From: Richard Castro-Parker
Sent: 05 September 2019 09:57
To: Samantha Lee
Subject: FW: BE/139/18/PL - Innovation Centre Beeding Close

From: Laura Gibbons
Sent: 30 August 2019 11:57
To: Richard Castro-Parker <Richard.Castro-Parker@arun.gov.uk>
Subject: RE: BE/139/18/PL - Innovation Centre Beeding Close

From: Richard Castro-Parker
Sent: 21 August 2019 12:10
To: Laura Gibbons <Laura.Gibbons@arun.gov.uk>
Cc: Daniel Vick <Daniel.Vick@arun.gov.uk>
Subject: FW: BE/139/18/PL - Innovation Centre Beeding Close

- Proposed Drainage Layout – 1:100 Scale;
- Proposed Drainage Layout – 1:400 Scale.

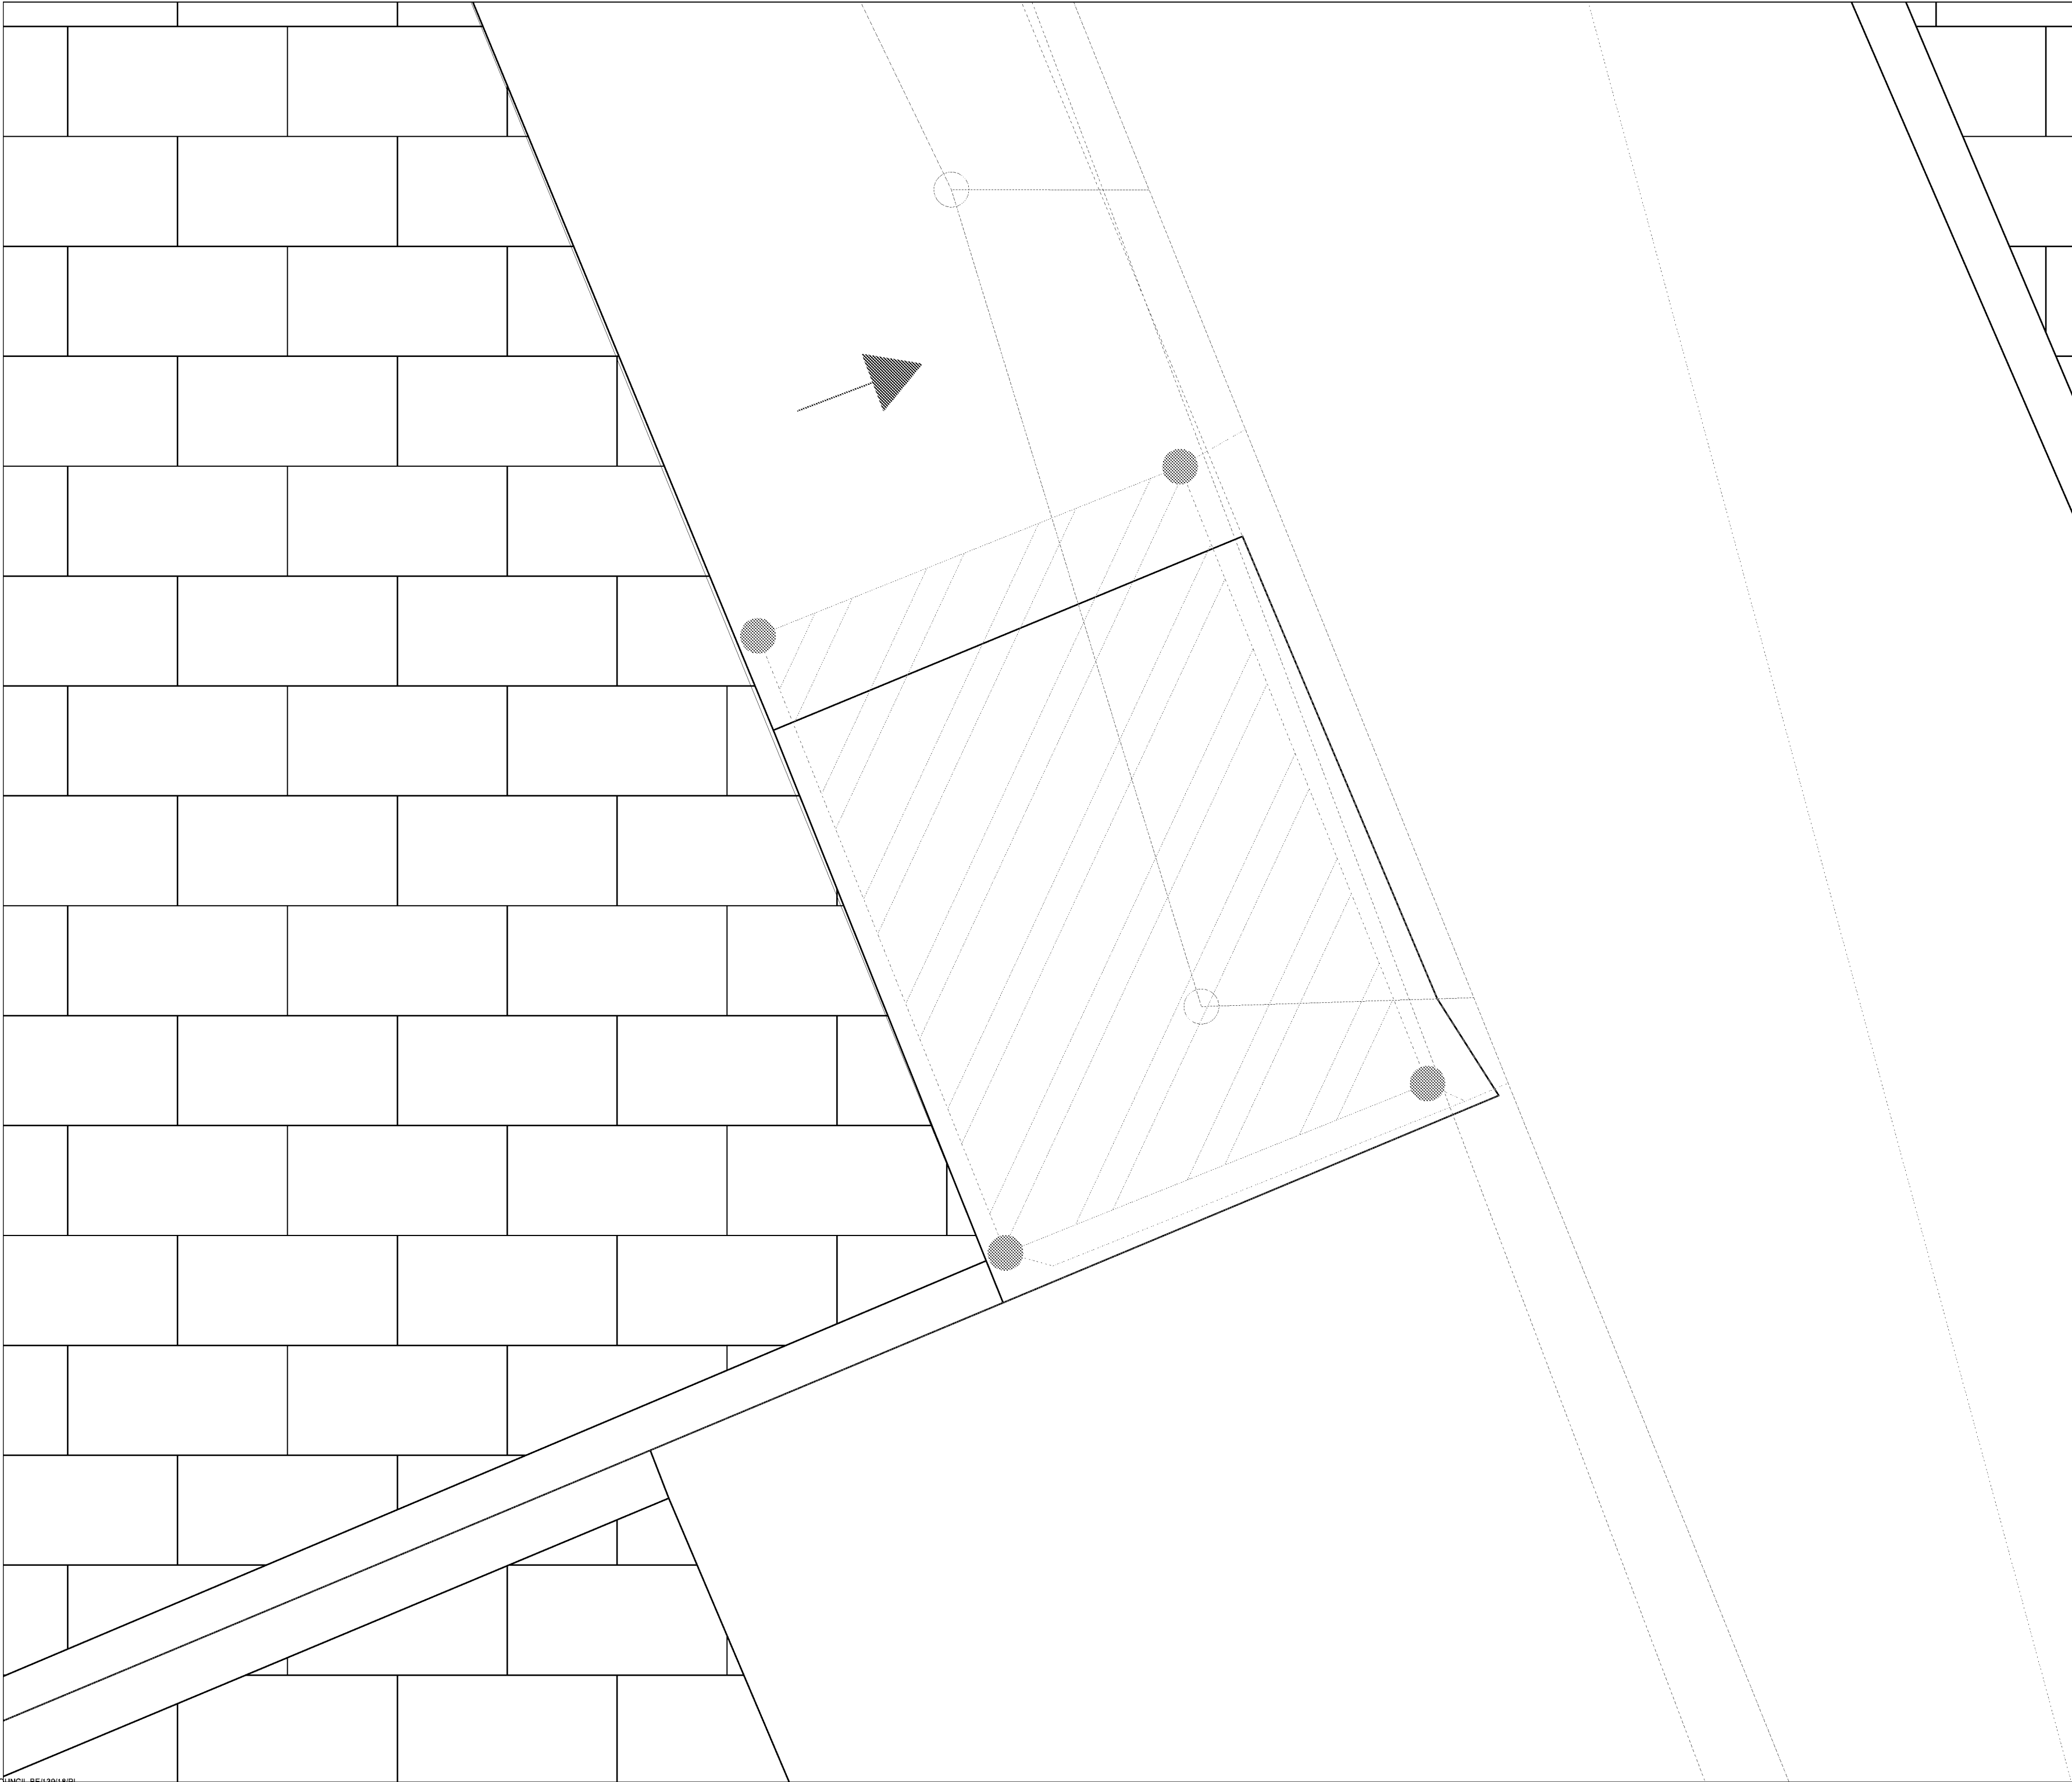
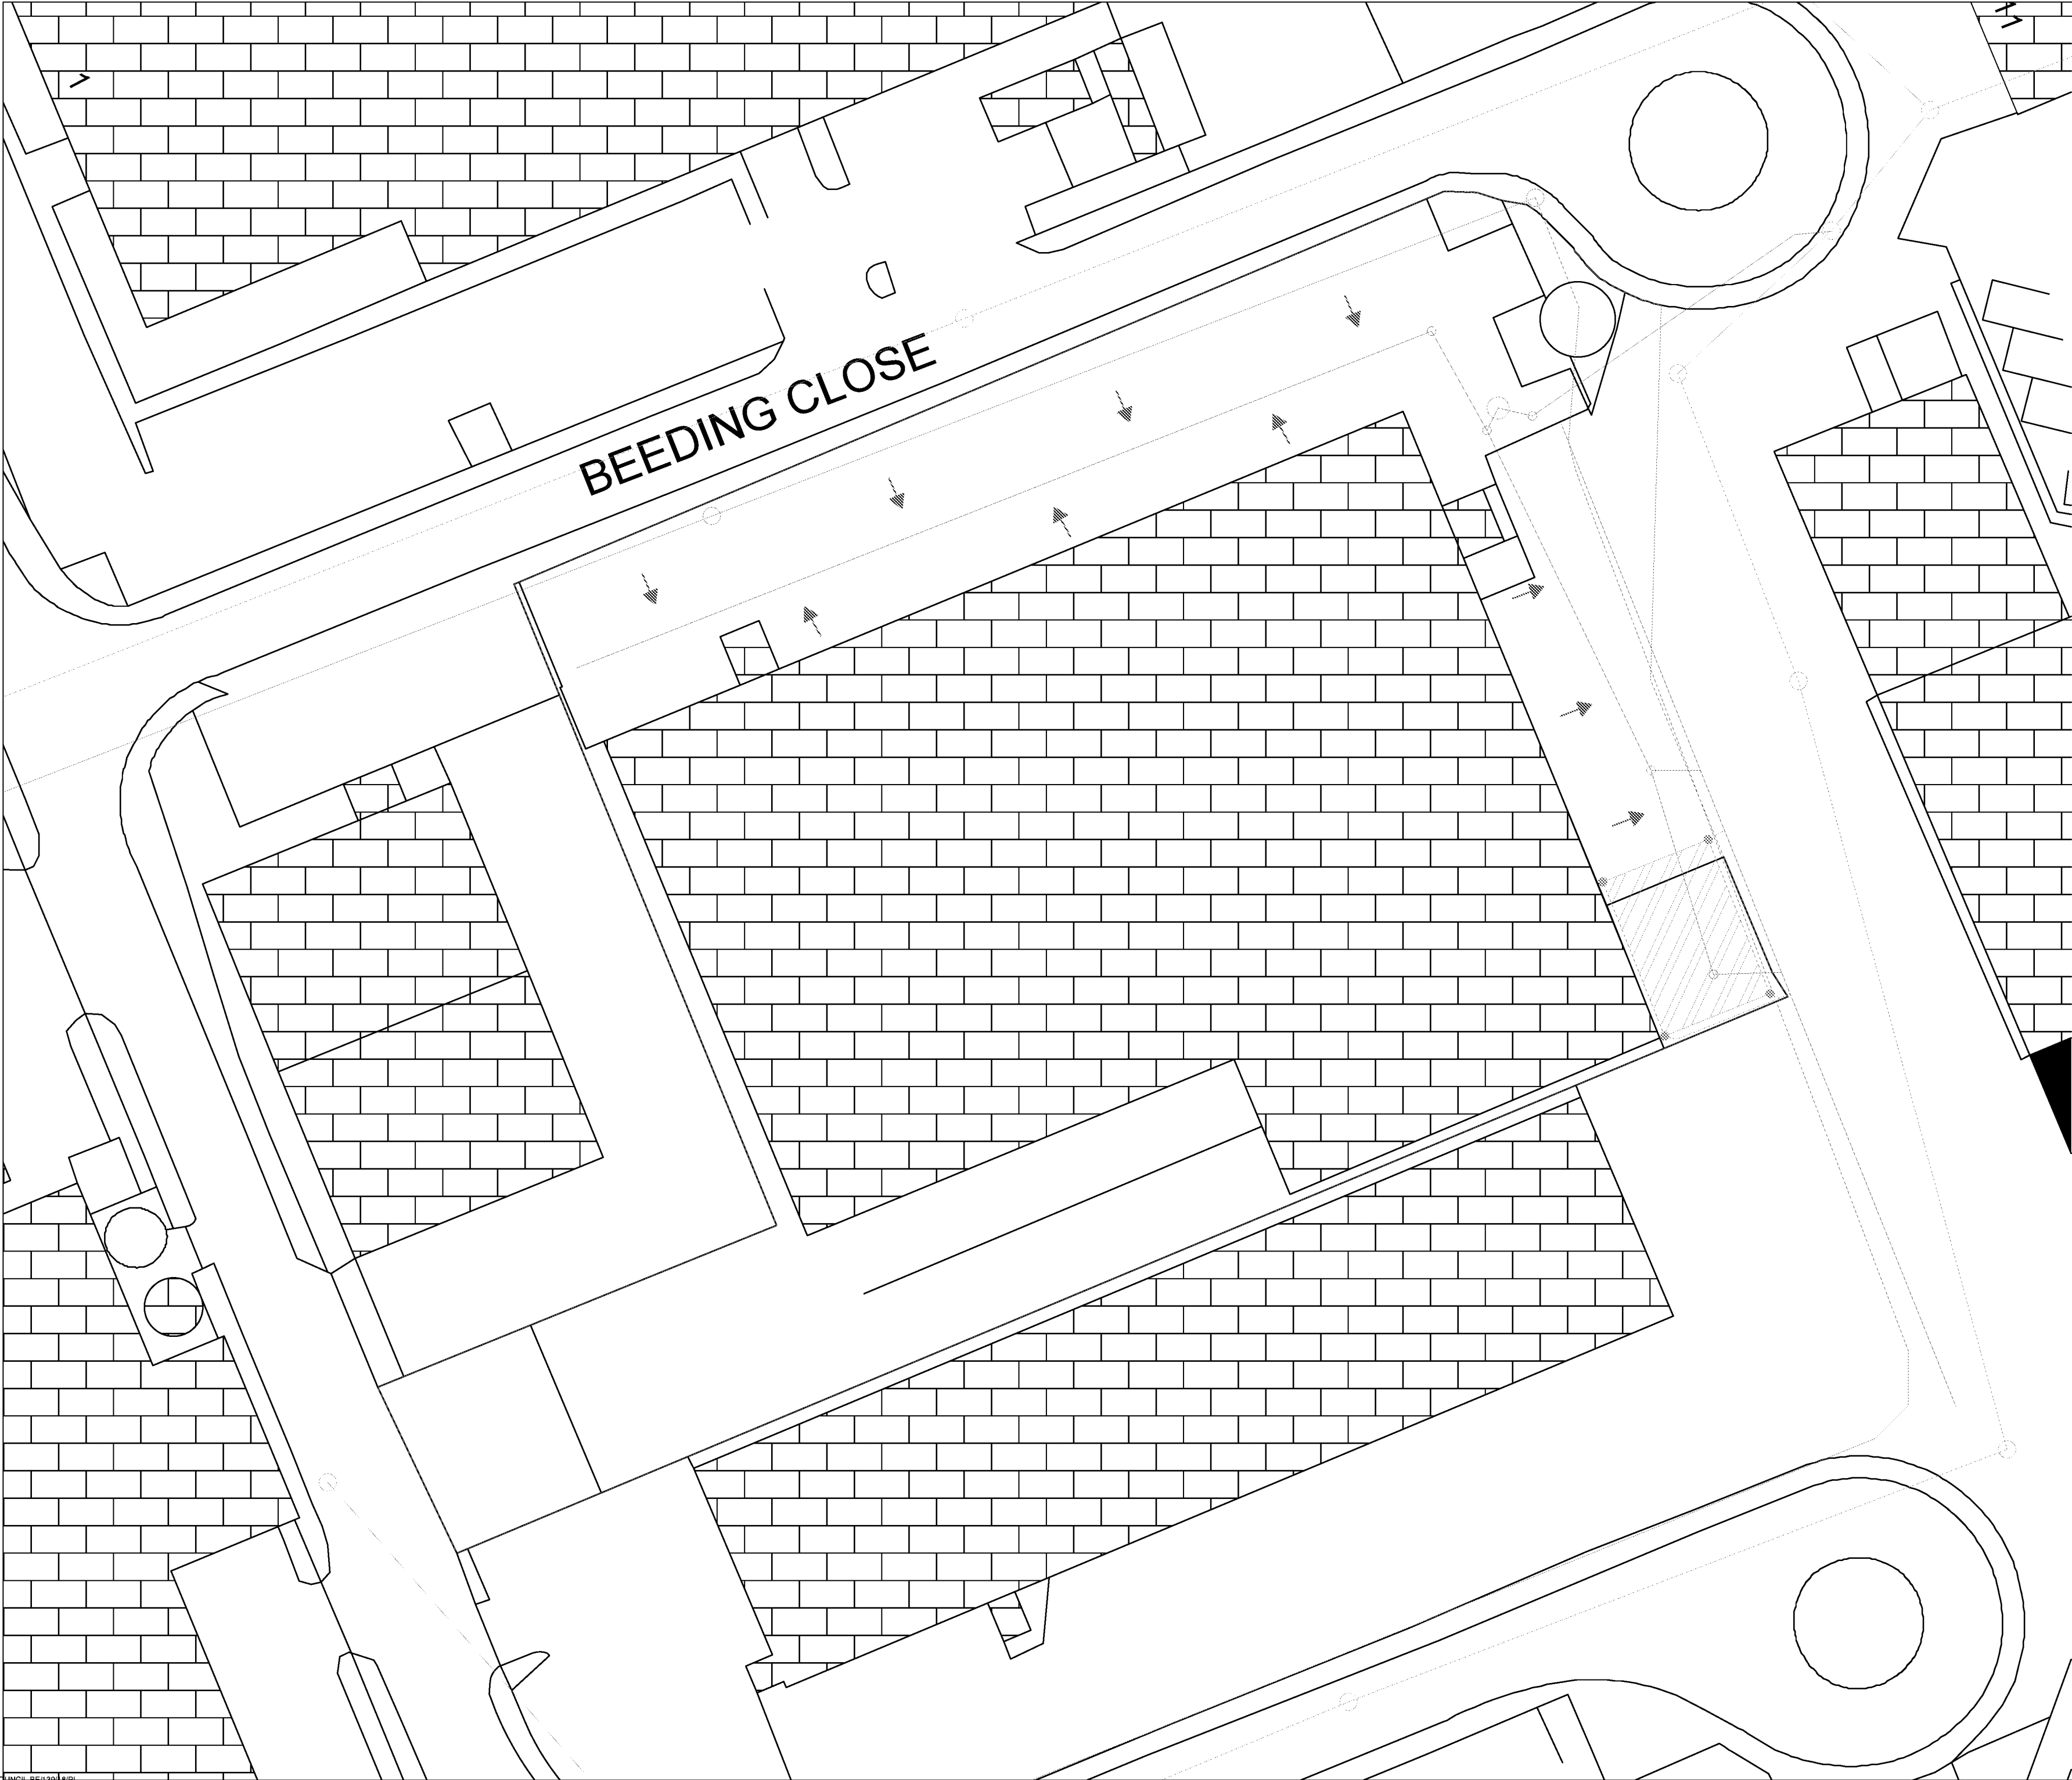
I still am struggling to distinguish between lines. Please can different line types be used, rather than all very similar colours. Please can gullies, manholes, and linear drainage channels be clearly labelled.

Regarding the levels, I also requested some spot levels of the surrounding land, can these be provided. This is fundamental to ensure that the surface water from the development does not go off site.

Please can the applicant submit clearer plans of the proposed surface water drainage arrangement. I.e. different line types used, rather than all very similar colours. Please can gullies, manholes, and linear drainage channels be clearly labelled.

I also require levels to be submitted showing invert and cover levels of the existing drainage network and spot levels of the surrounding land. This is fundamental to ensure that the surface water from the development does not go off site.

Please find attached a PDF of the drainage layout plan for the site. Given the size of the site, all lines on the plans are small. However, if Laura zooms in she will be able to distinguish between the pipes types. This should hopefully address her first concern.

With regards to levels, having reviewed the sewer asset location search requested from Southern Water, both invert and cover levels for all Southern Water manholes are detailed within their response. A copy of the sewer asset location search was included within the appendix of the Surface Water Drainage Strategy – this have been attached to this email for her reference.
